Subject: **Revised Permit Modification Request for the Section 404 Individual Permit, Section 401 Individual Water Quality Certification and CAMA Major Development Permit** for the proposed improvements to US 70 from existing four lanes at Radio Island to north of Olga Road (SR 1426), Carteret County, State Project No. 8.1162501, Federal Aid Project STPNHF-70(43), TIP R-3307, Debit \$570 (NCDWR) and \$100 (NCDCM) from WBS 34528.1.1

This revision serves to update the Permit Modification Request, dated June 1, 2016. The stream impact and surface water total at site 2 has been amended with the as-built total.

N.C.D.O.T.
 DIVISION OF HIGHWAYS
 CARTERET COUNTY
 PROJECT: 34528.1.1 (R-3307)
 US 70 FROM EXISTING FOUR LANES
 AT RADIO ISLAND TO US 70 NORTH
 OF SR 1429 (OLGA ROAD)

REMOVE 48" RCP  
& FES  
REPLACE WITH 72" RCP  
54 LF  
BURY ONE FOOT  
INSTALL HW'S ON  
BOTH ENDS  
RETAIN EXIST RIP RAP

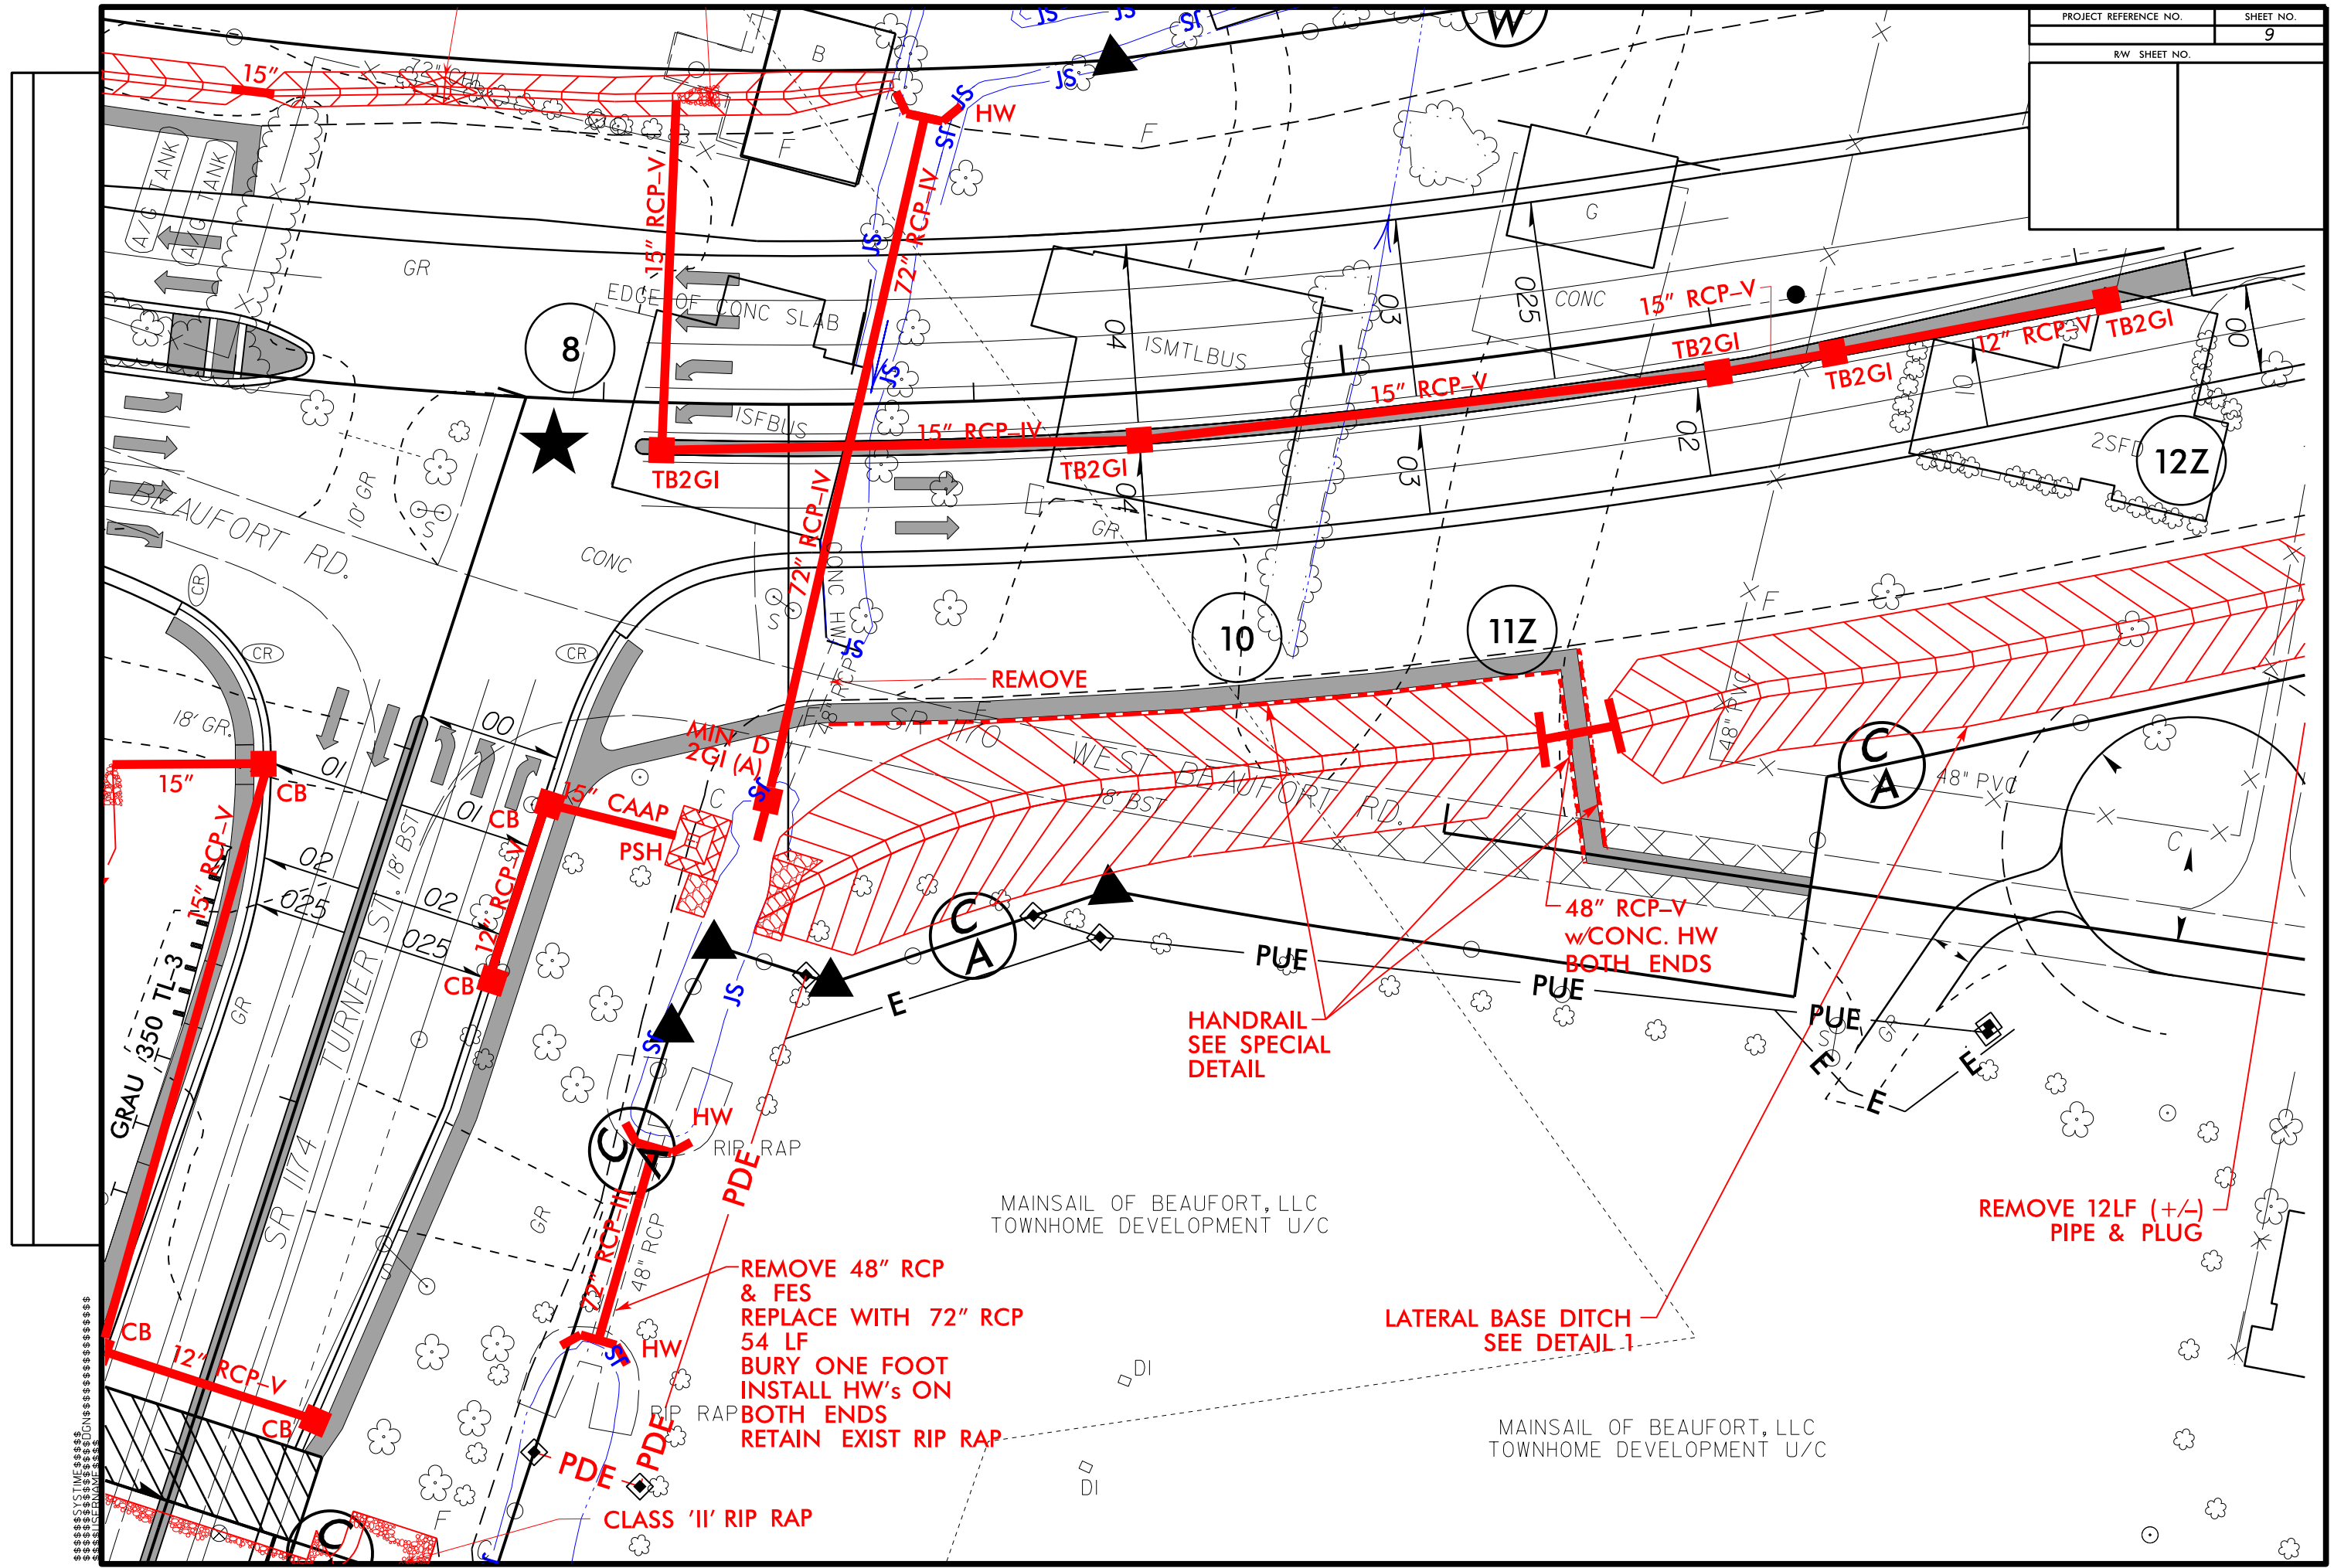
Also note, the 48" RCP and Flared End Sections installed by the developers of the MAINSAIL

property are being removed and replaced by NCDOT. The replacement pipe will be a 72" pipe with headwalls on both ends. The pipe will be buried one foot and the existing rip rap will be maintained. There are no additional impacts to the stream.
